# Site Development Plan\_v1.pdf Markup Summary

**OUTLET STRUCTURE PROFILE DETAIL**  
N.T.S.

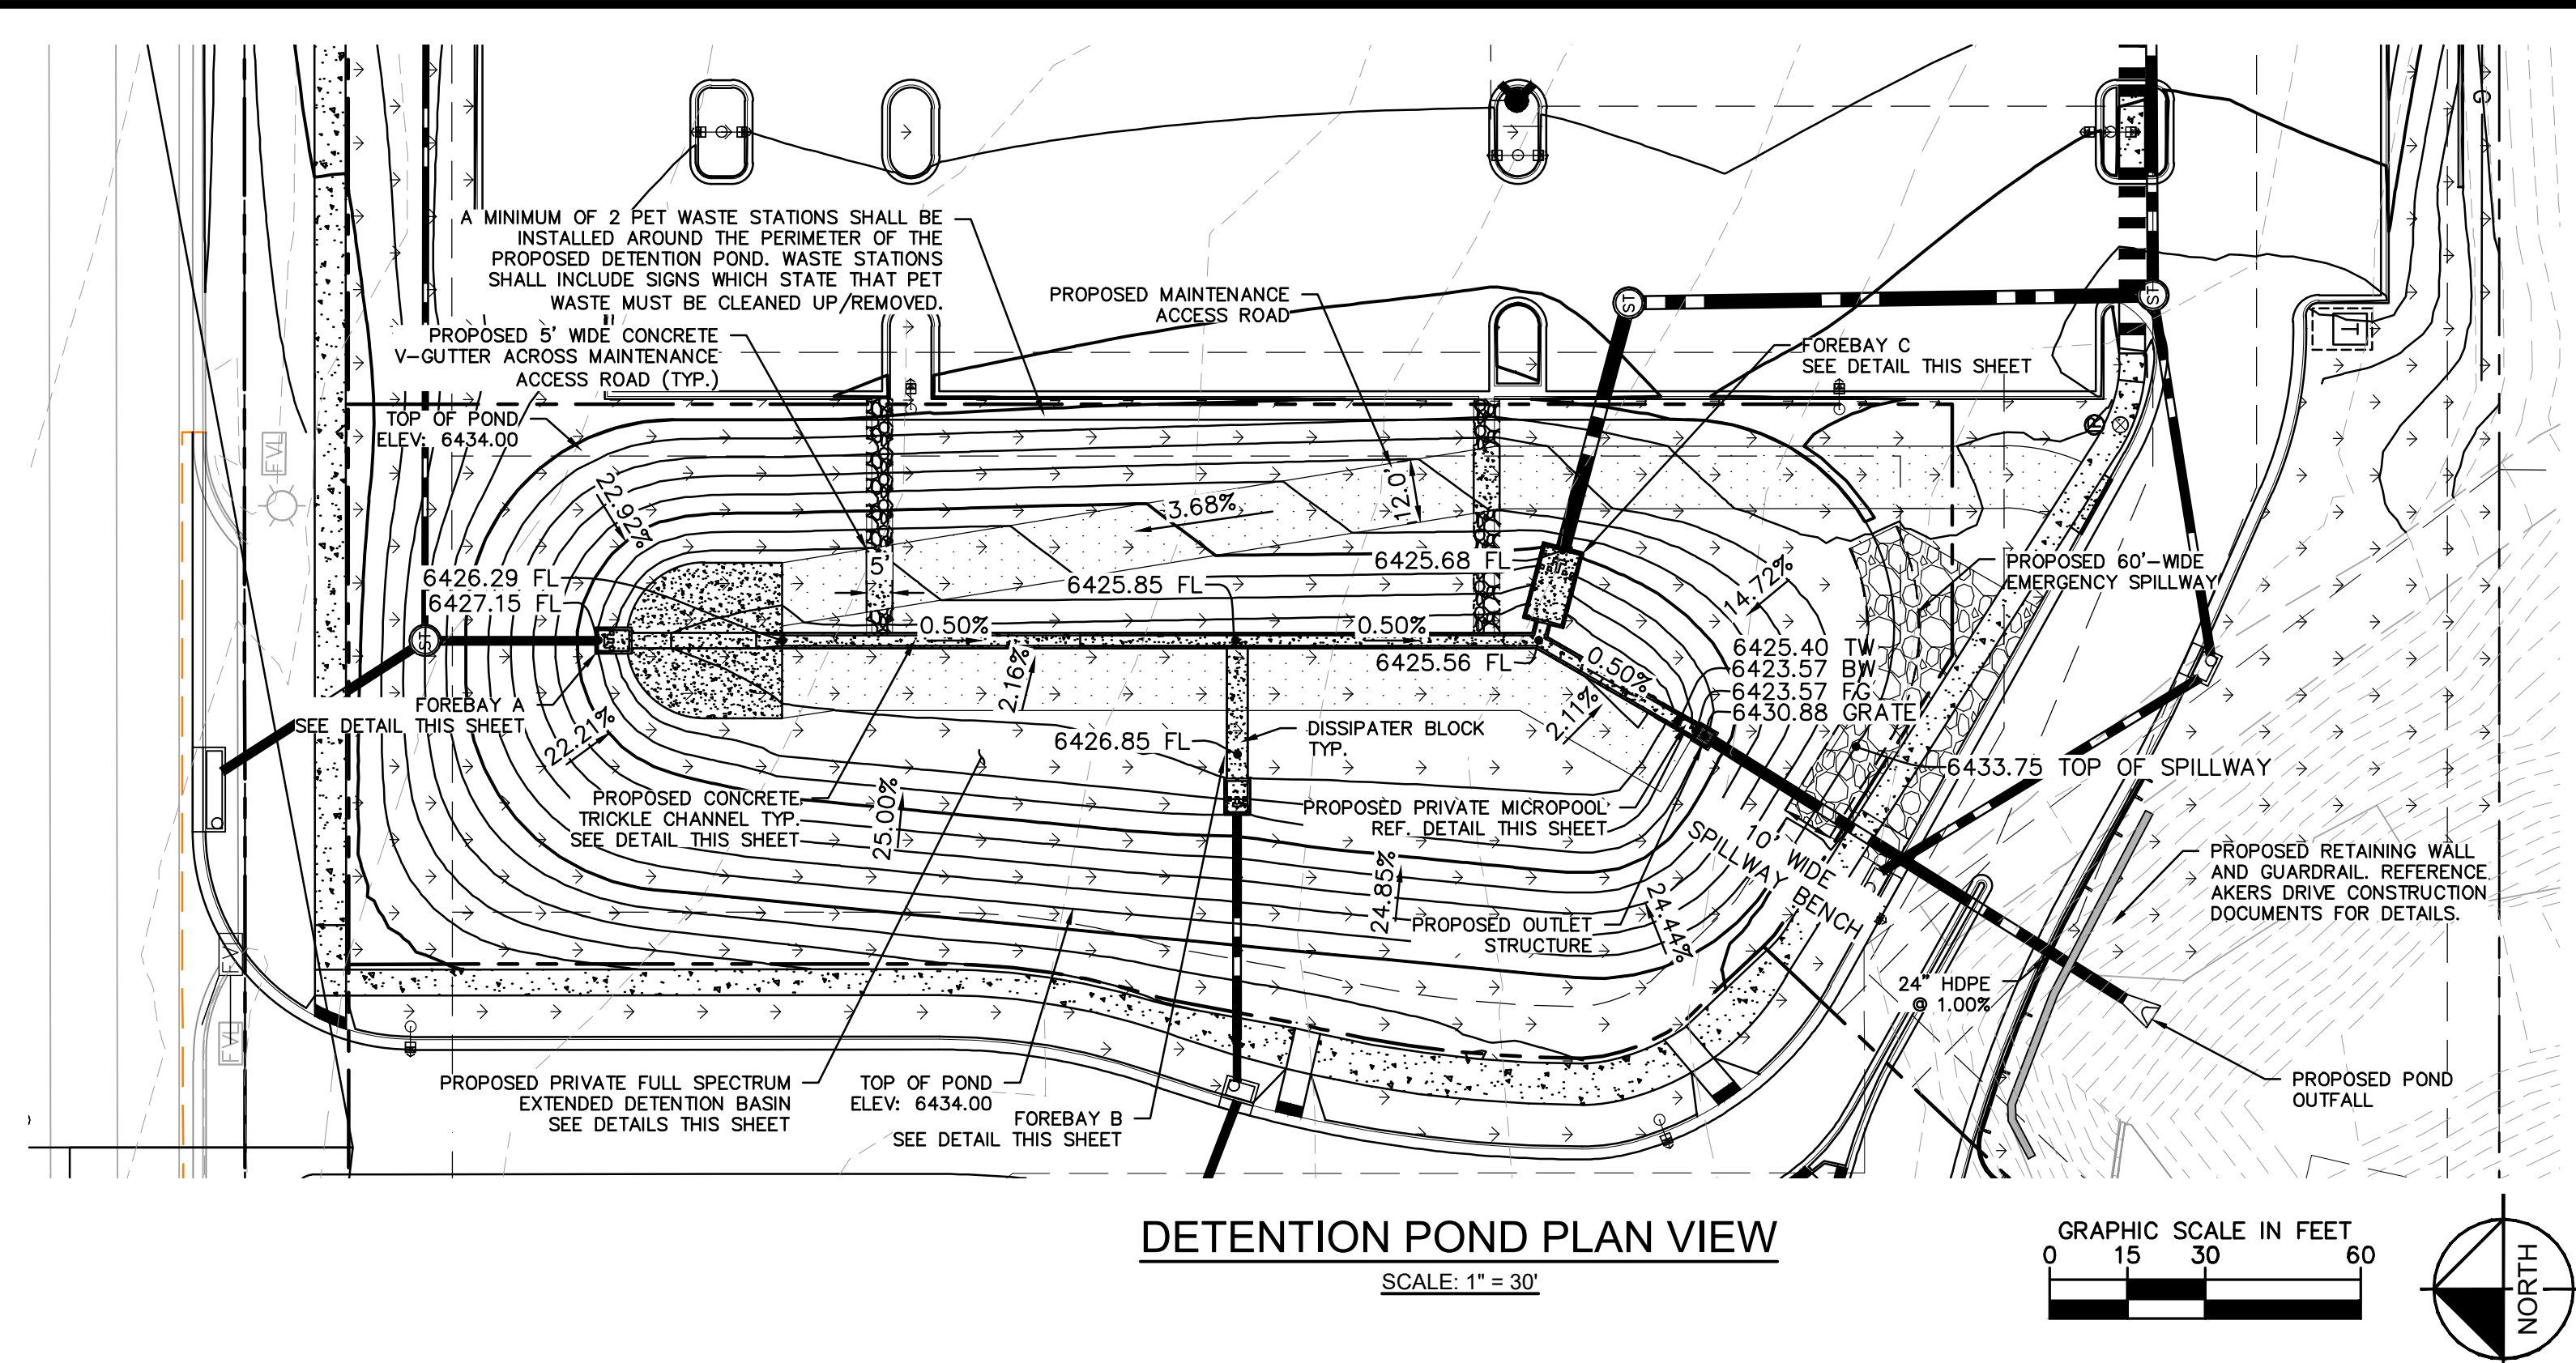
Please identify the elevation at the top of the outlet structure
